CBD and South-East Light Rail Project

The following responses apply to both Volumes 1 and 2 of the CBD and South-East Light Rail Project: EIS SUBMISSIONS REPORT dated March 2014.

Figure 1: WAG preferred alignment for the CSELR in the vicinity of Wansey Road

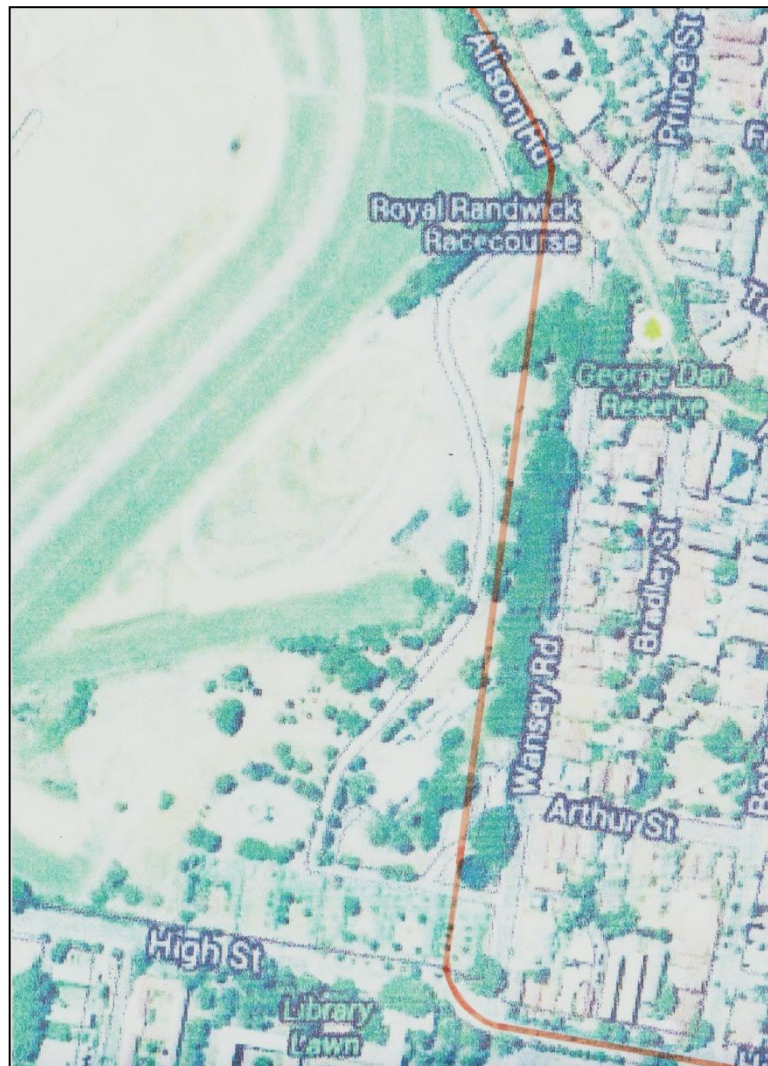
The proposed alignment of the Wansey Road section of the route has greatly diminished the role and accessibility of the LRT system. As a street based system, the LRT should be integrated as part of the street, within the reserve, and without the loss of significant trees to the Racecourse edge.

The loss of substantial trees at this location is unnecessary, and should be avoided. We note that no new significant plantings are shown on the plan or section.

We note the dismissal of an option to run the line through the racecourse, due to the removal of stables. It is noted that this land is due for redevelopment. As such, the LRT should be located to adequately service this high density renewal site as well as preserve the Wansey Road figs and street character, should integration with Wansey Street not be feasible. The stop therefore in this location should be able to better serve the anticipated uplift in residents.

Figure 2.1 - Typical section through Wansey Road Stop (sourced from EIS Figure 10.5).

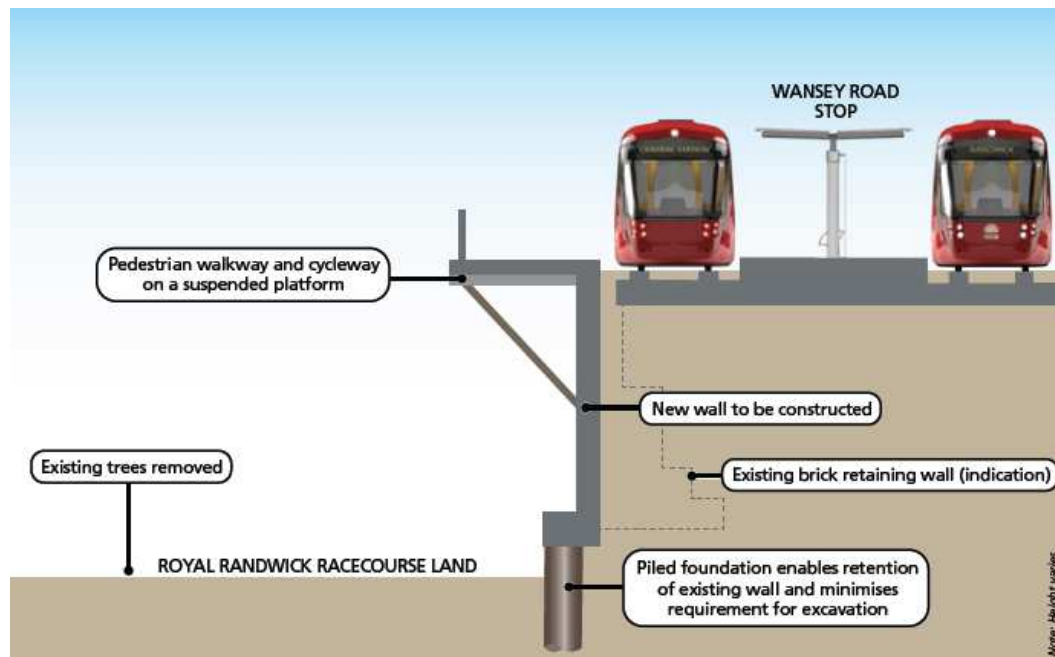
- **Figure 6.12** - This alignment and station location is not supported:

Reference is made to the above points, and we advocate the redesign and integration of the Wansey Street stop to suit a more superior alignment. We note that no new significant plantings are shown on the plan.
